From: Lake , Wayne (GROUP LEADER HDC) <WayneLake@barnsley.gov.uk>
Sent: 12 September 2023 15:46
To: Hyde , James (SPATIAL PLANNING PROJECT MANAGER)
Cc: HighwaysPIngApps
Subject: FW: 2022/0115 - Land north of Shaw Lane, Carlton, Barnsley, S71 3HH

Re: 2022/0115 - Residential development of up to 215 dwellings with associated car parking/garages, landscaping, public open space including both equipped and non-equipped areas of play, SUDS and drainage, with details of a new vehicular access onto Shaw Lane (Outline with all matters reserved apart from means of access)

Many thanks for consulting Highways Development Control on the additional information submitted in respect of this application, covered by the Letter from Spawforths dated 2 June 2023.

5.4 Offsite Highway Works – Changes to footway on Shaw Lane

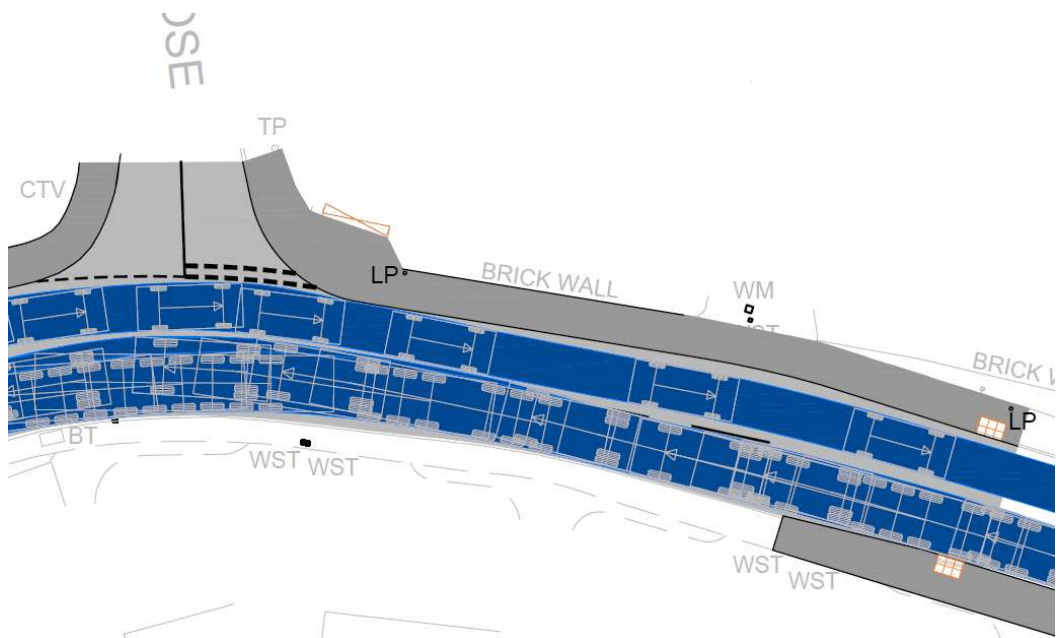
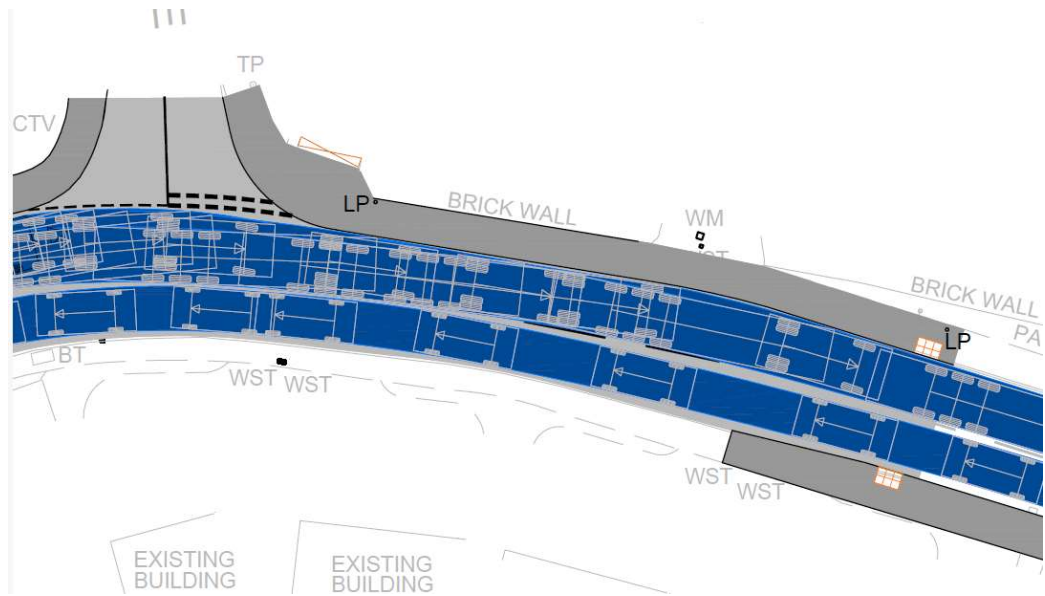
The plan shows indicative primary signal head locations – this reduces the footway widths to circa 1.2m in some places. This is below the desirable minimum and provides constraint for those with reduced mobility, pushchairs etc as well potentially restricting safe access for maintenance etc.
